PLANNING CONSULTATION RESPONSE

Application No	2026/0420
Proposal	Erection of 10no. 2 and 3 storey detached dwellings
Address	Land west of Sheffield Road, Birdwell, Barnsley
Date of Consultation Reply	28/07/2026
Consultee	Pollution Control

Consultation Assessment and Justification

Figure 3.1 Survey measurement positions

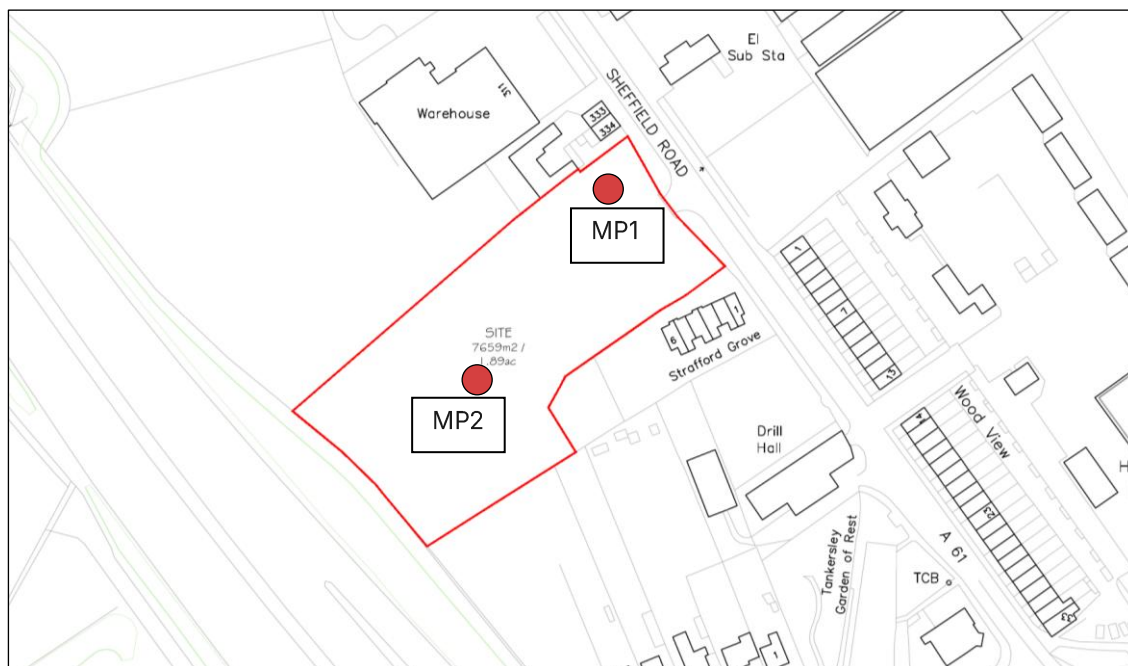
- MP2 is the location closest to the M1, yet measurements were only taken for 1 hour on a single day. Is there a reason for this?
- It is not clear whether there was any event/performance occurring at the theatre during the periods that noise levels were being measured. If there was, can the detail of this be provided? If not, then further measurements would be required to be taken during a representative event.

Appendix B – Noise Model Results

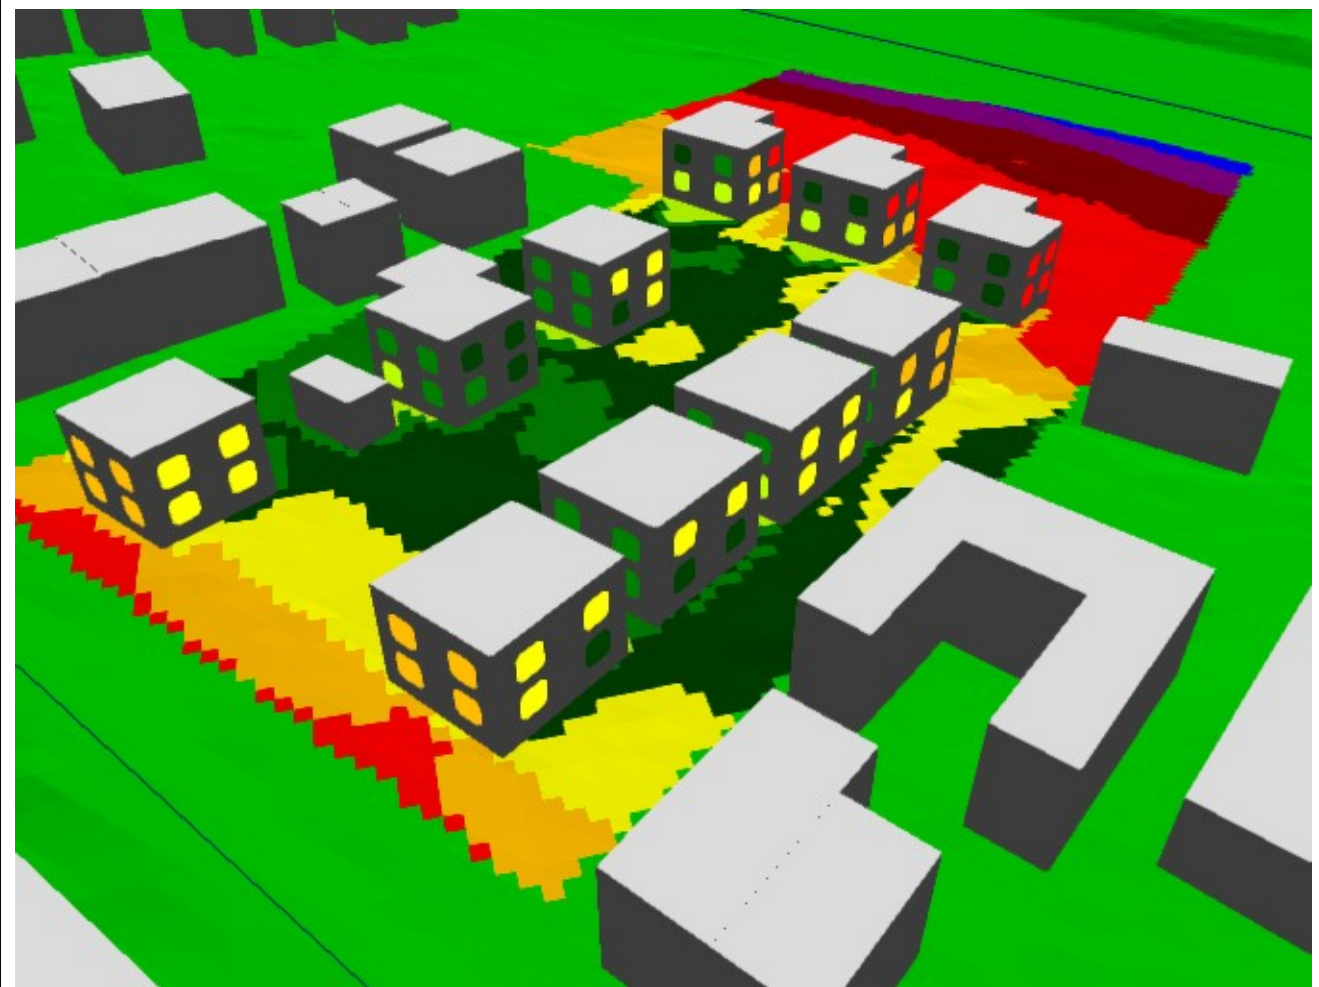
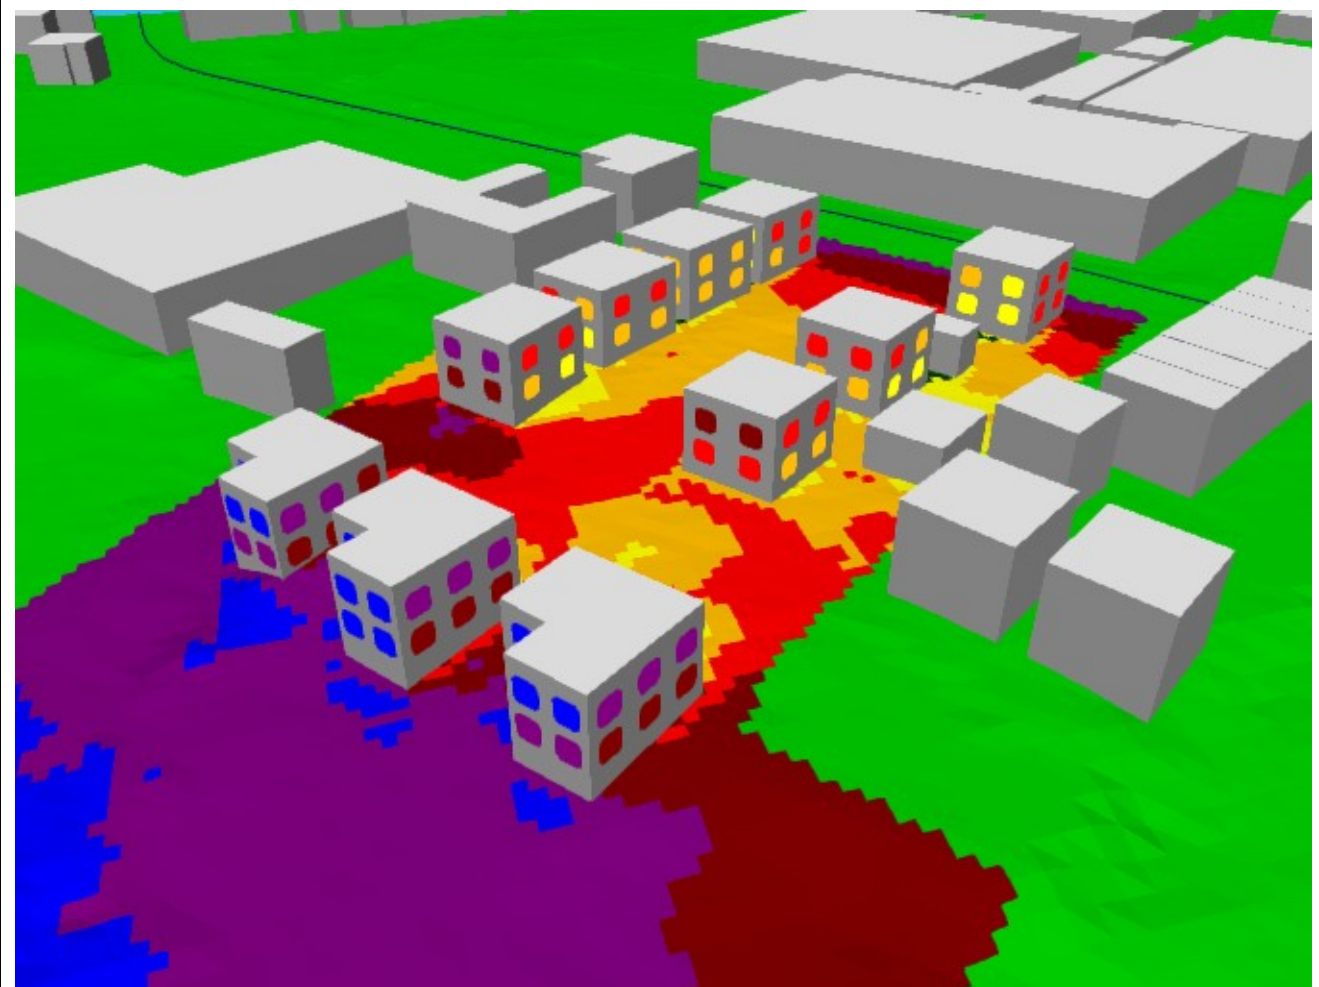
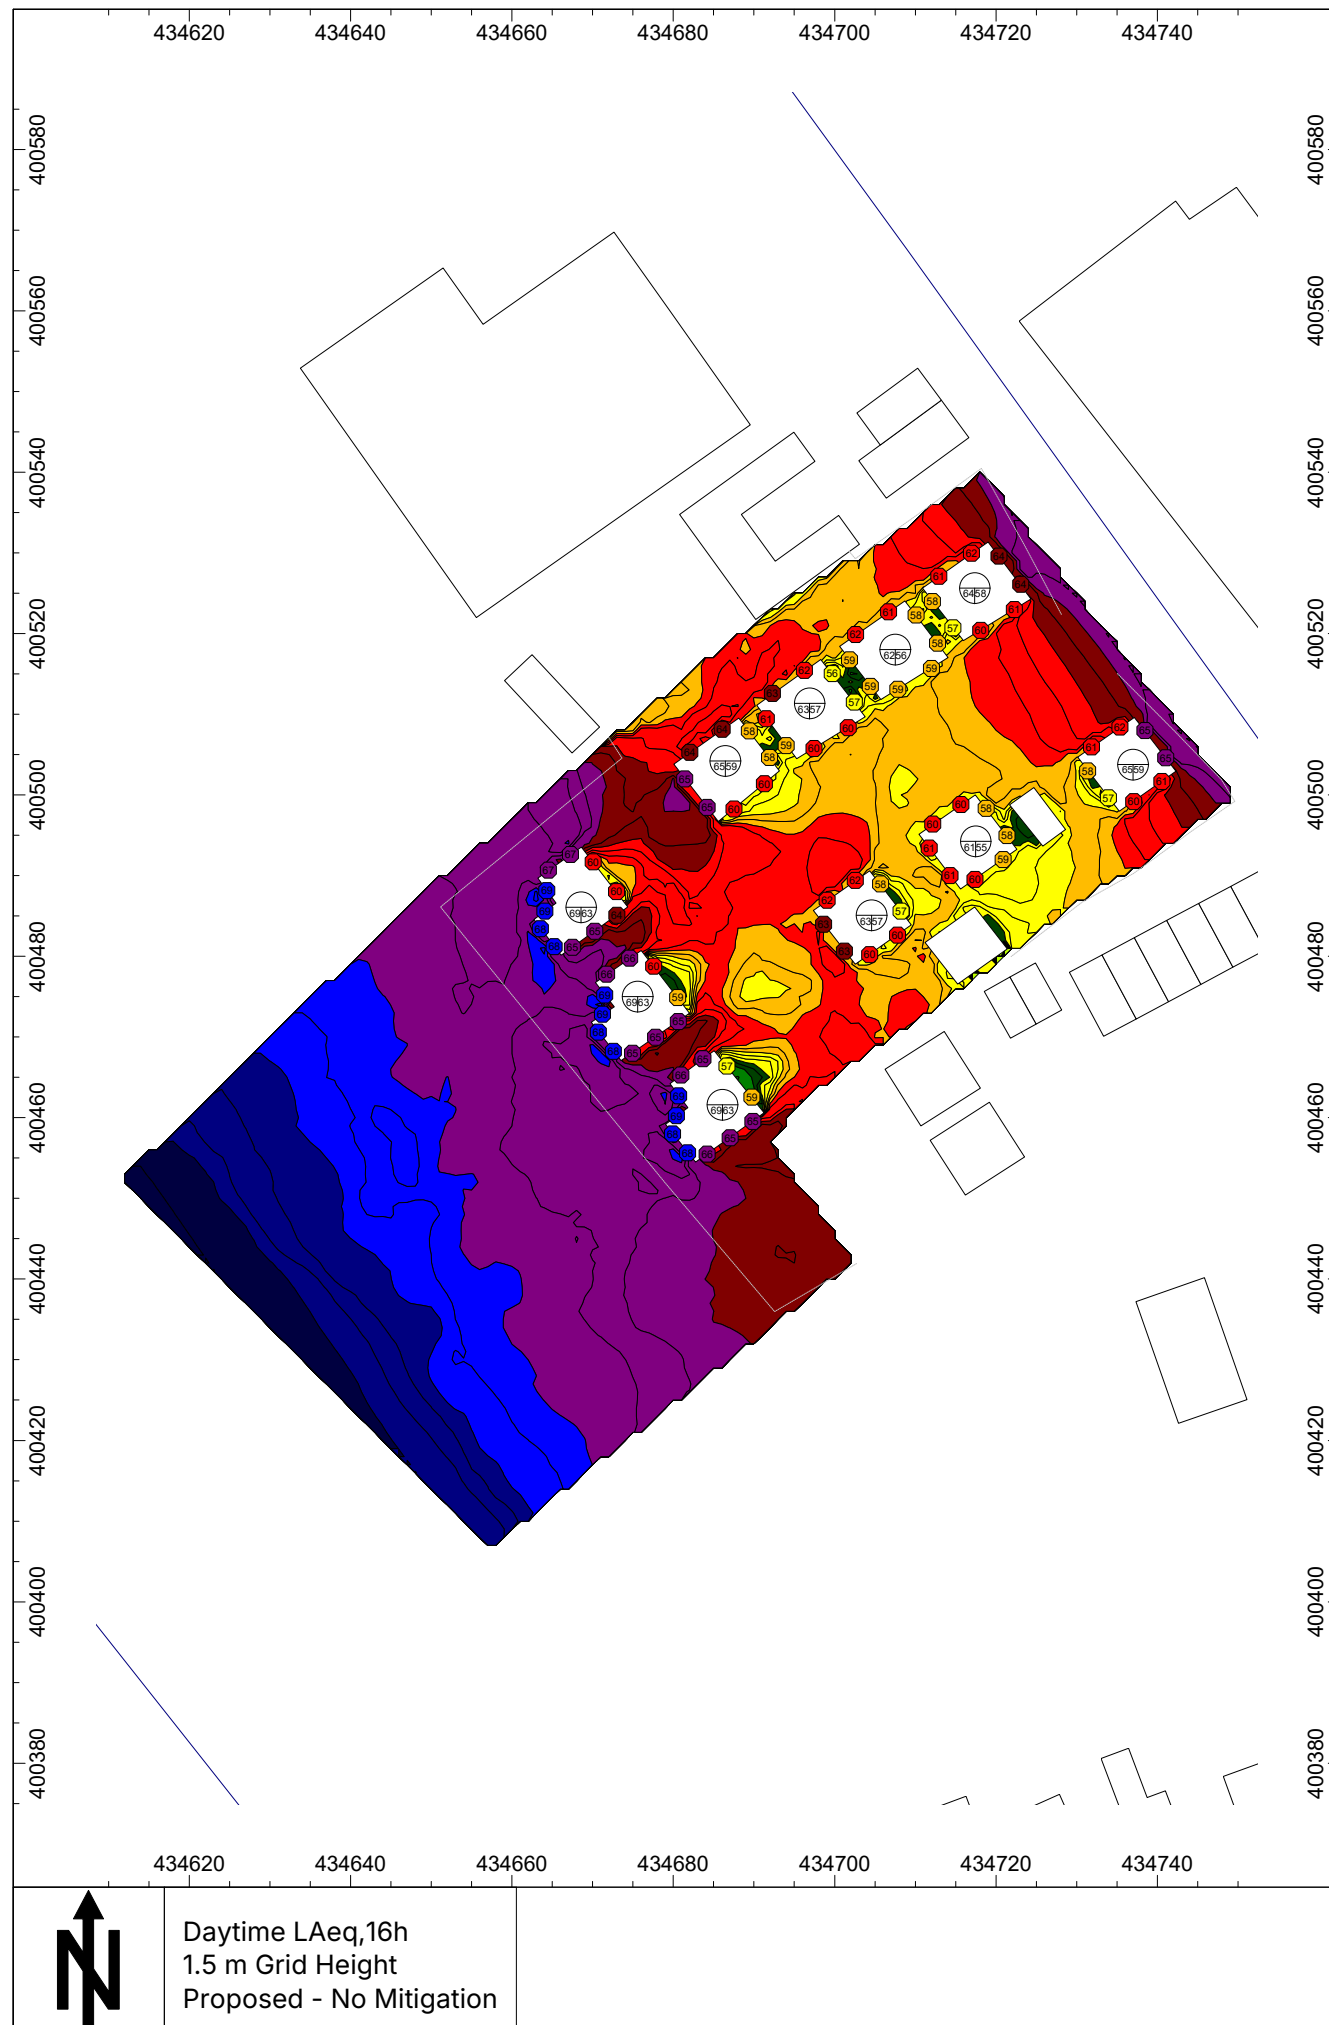
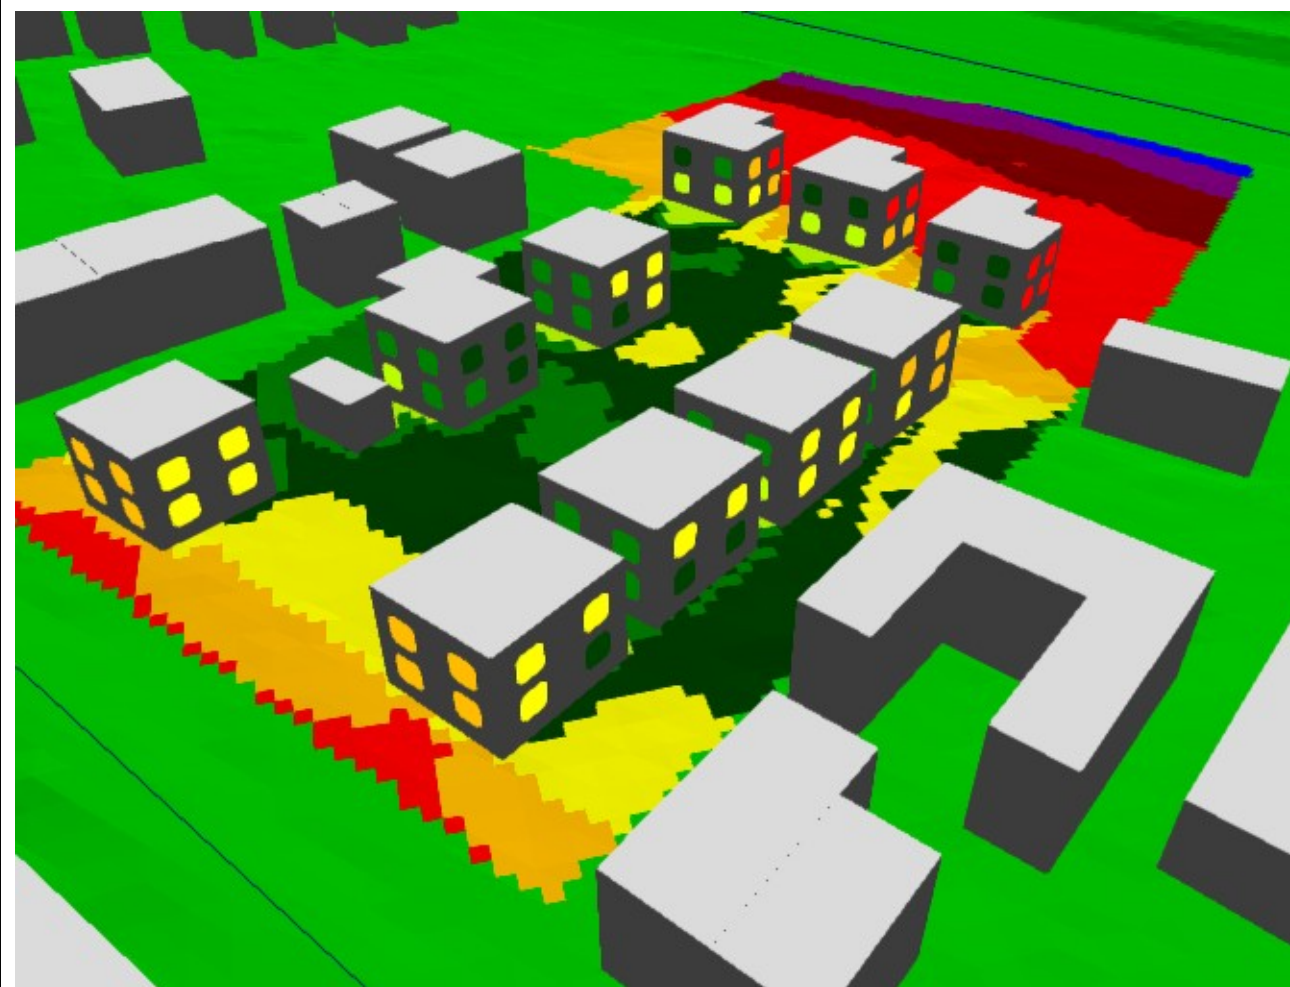
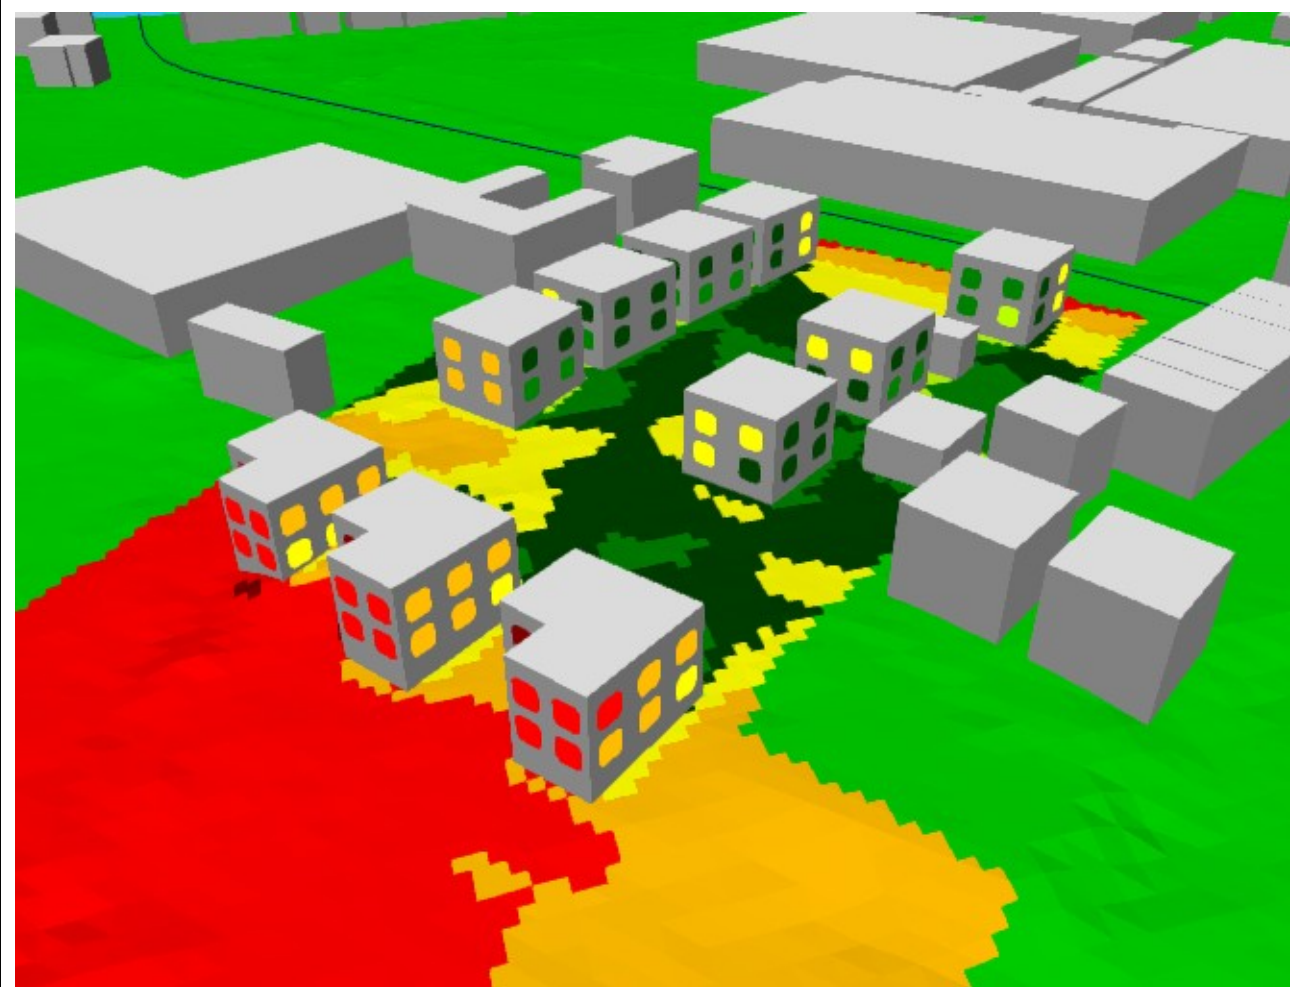
- The modelling in Appendix B appears to show daytime noise levels in the outdoor amenity areas closest to the M1 to be 55dB to 65dB LAeq, 16h, with mitigation. Yet the report states that with mitigation "daytime noise levels within the majority of the proposed gardens are predicted to be approximately 55dB LAeq, 16 hr or below". Further clarity on the noise levels in the outdoor amenity spaces is required.
